Rezoning Transportation Analysis

Petition Number: 2020-023

From: Felix Obregon, PE
fobregon@charlottenc.gov
704-432-5729

Date	Description
03-20-20	First Review

RZ-1.0

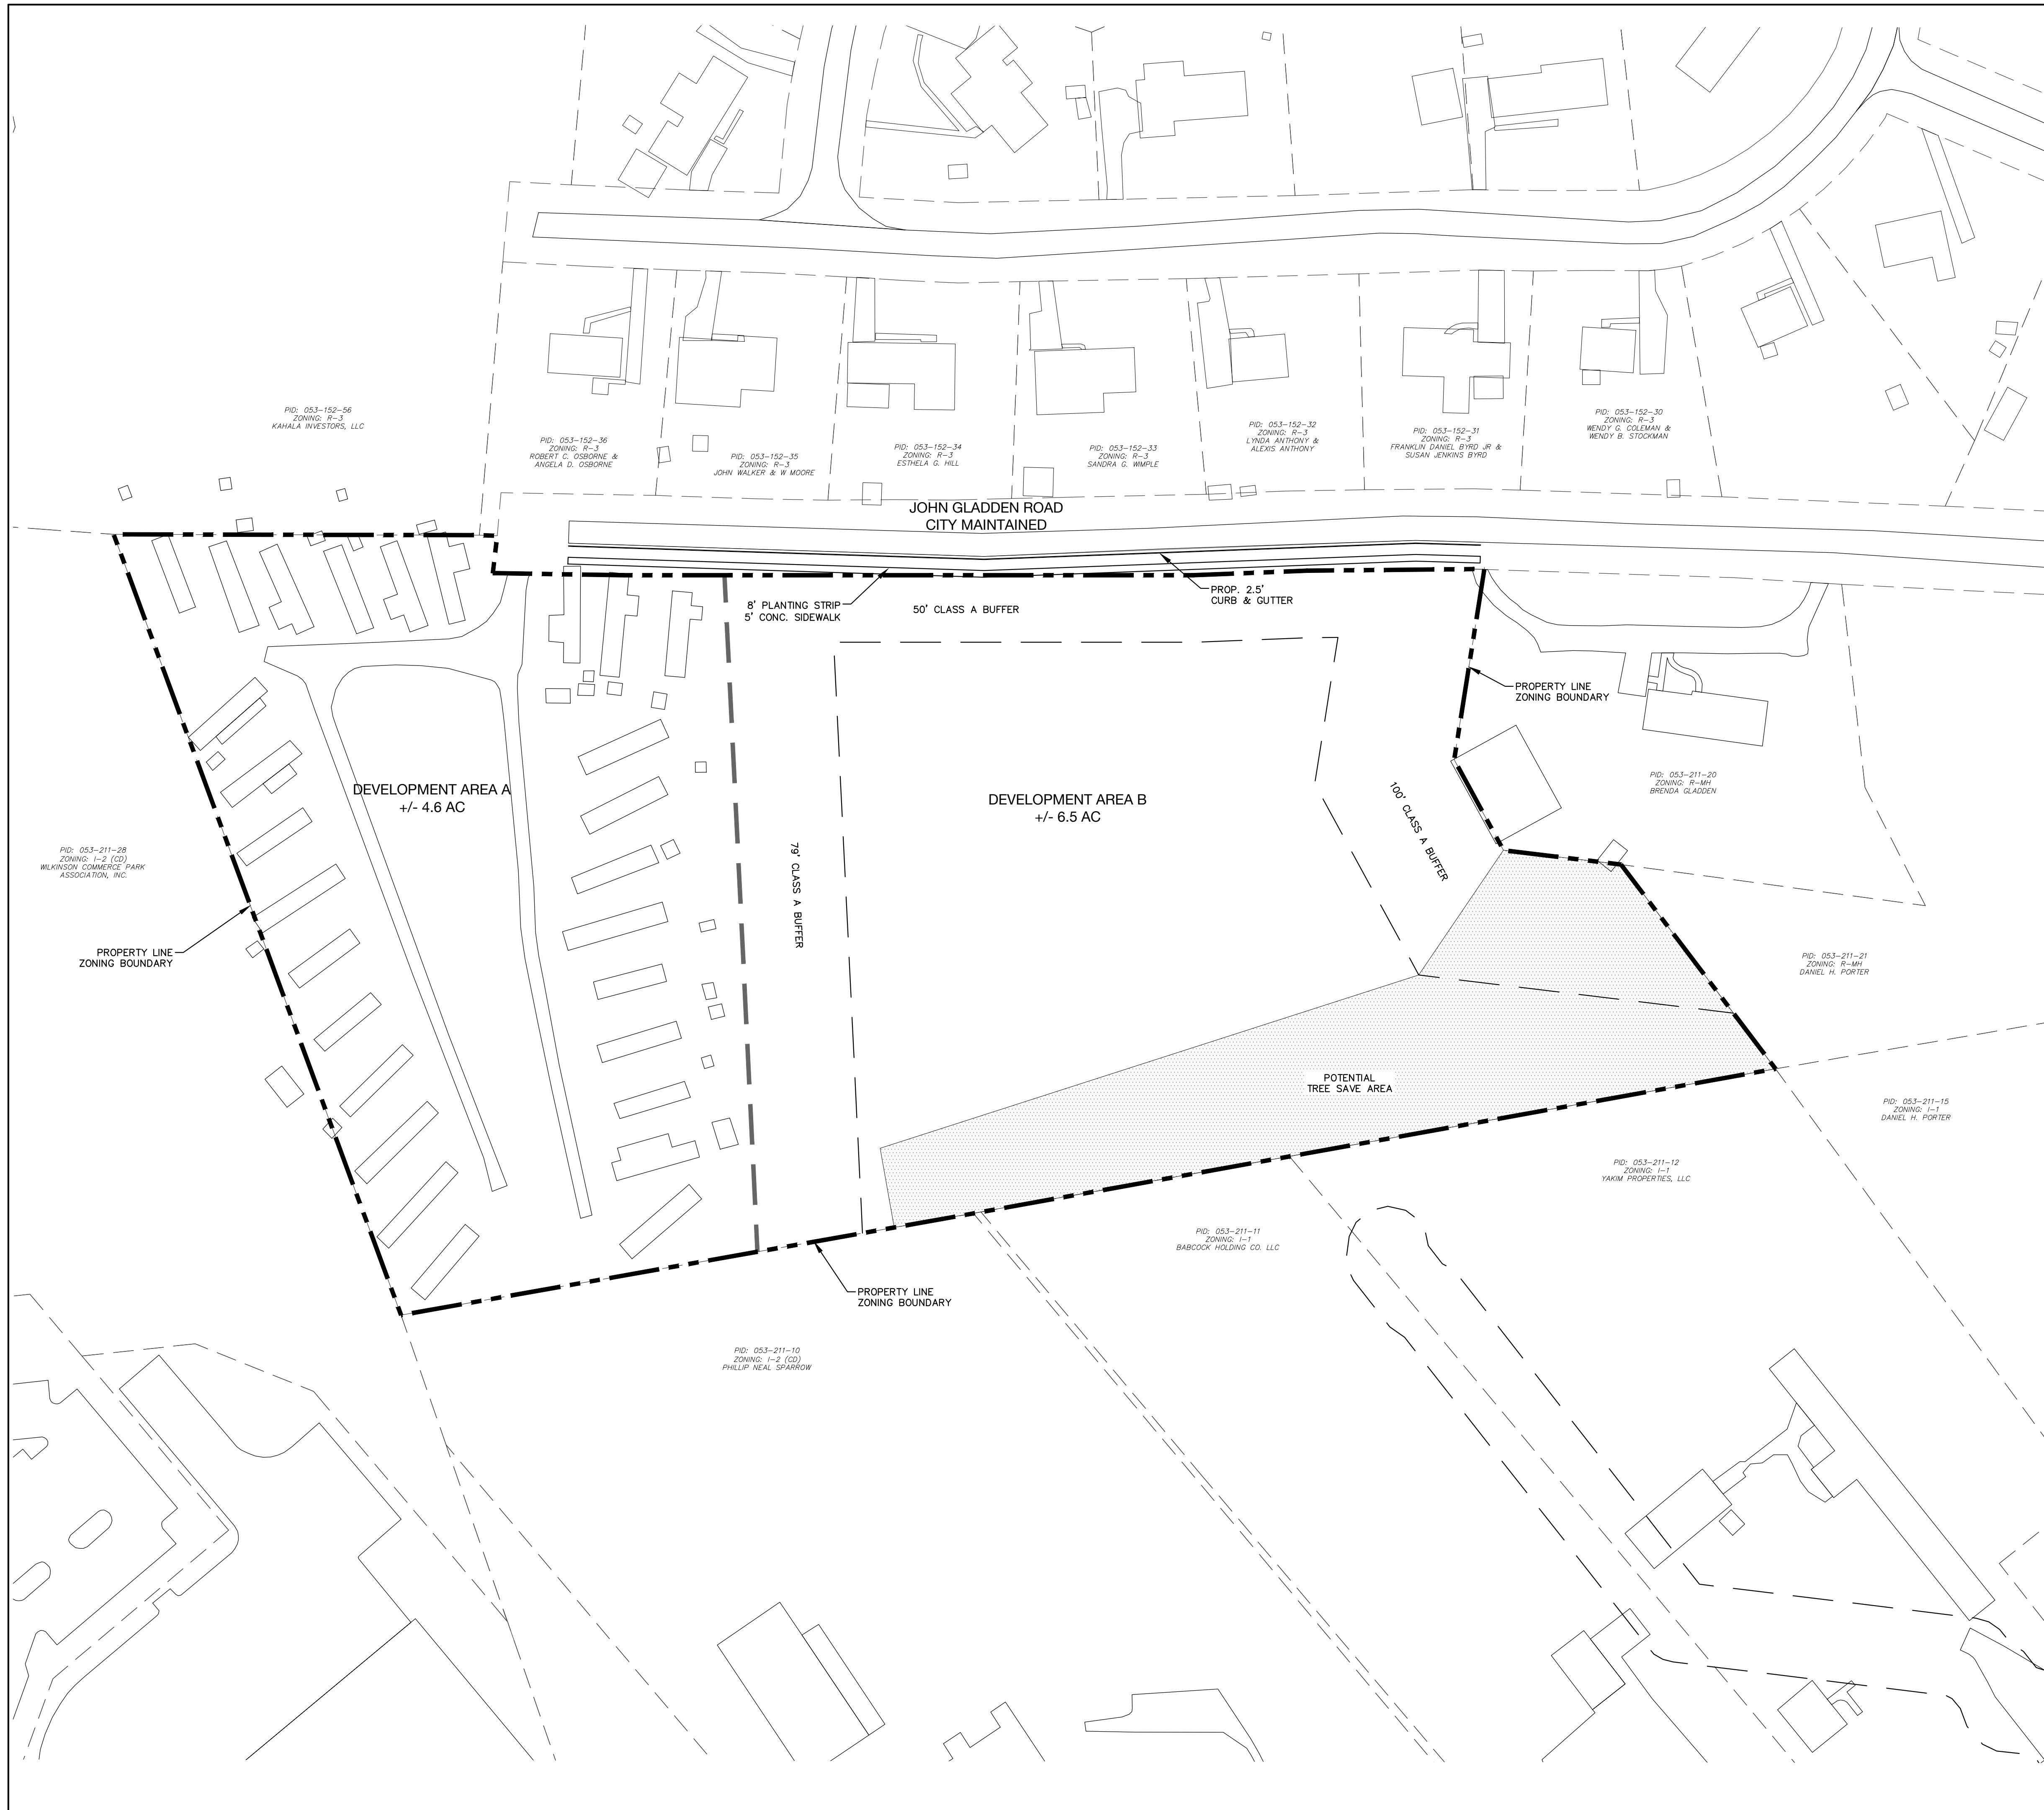
- a. **John Gladden Road:** The future location of curb and gutter is recommended to be placed 17.5 feet from existing road centerline, per Charlotte Land Development Standards Manual (CLDSM) U-06 Local Industrial Street Typical Section. This is an ordinance requirement.

3. CDOT recommends for the petitioner to revise the site plan and conditional note(s) to commit to construct an 8-foot planting strip, and 5-foot sidewalk on John Gladden Road, consistent with public street standards. The site plan should label and dimension both items from the back of curb and gutter and road centerline. This is an ordinance requirement.

4. The petitioner should revise the site plan to include turning movements of the largest design vehicles that will be accessing the proposed site. All turning movements should be shown at the intersection of John Gladden Road and Sam Wilson Road. Please also show the existing pavement striping with the proposed turning movements. If the turning movements cannot be maneuvered within the existing roadway configuration, a realignment will be required. If turning movements can be maneuvered, the access will be restricted to a right-in/right-out access with pavement widening. Refer to the NCDOT's Policy on Street and Driveway Access manual for guidance.

5. We request the petitioner to revise the site plan and conditional note(s) to realign John Gladden Road perpendicularly to Sam Wilson Road, which will likely be needed to accommodate turning movements. This option would involve acquisition of private property.

6. If realigning John Gladden Road is necessary, the petitioner should revise the site plan and conditional note(s) to commit to re-striping a left turn lane on Sam Wilson Road, in coordination with CDOT and NCDOT.

7. The petitioner should revise the site plan to remove the “city maintained” label under John Gladden Road. This road is not maintained by NCDOT and may either be privately maintained or unmaintained.

8. The petitioner should revise the site plan and conditional note(s) to include a Subdivision Ordinance required public street, designed per CLDSM std. no. U-06 – Local Industrial Street, as shown below.

9. The petitioner should revise the site plan to add a note specifying dedication and fee simple conveyance of all rights of way to the City before the site's first building certificate of occupancy is issued. CDOT requests right of way set at 2' behind back of sidewalk where feasible.
10. The petitioner should revise the site plan to add a note specifying all transportation improvements will be approved and constructed before the site's first building certificate of occupancy is issued. The petitioner may phase transportation improvements if said improvements and phasing are explicitly described in site plan notes.
11. ~~Resolved-Sample format for comment that is resolved~~
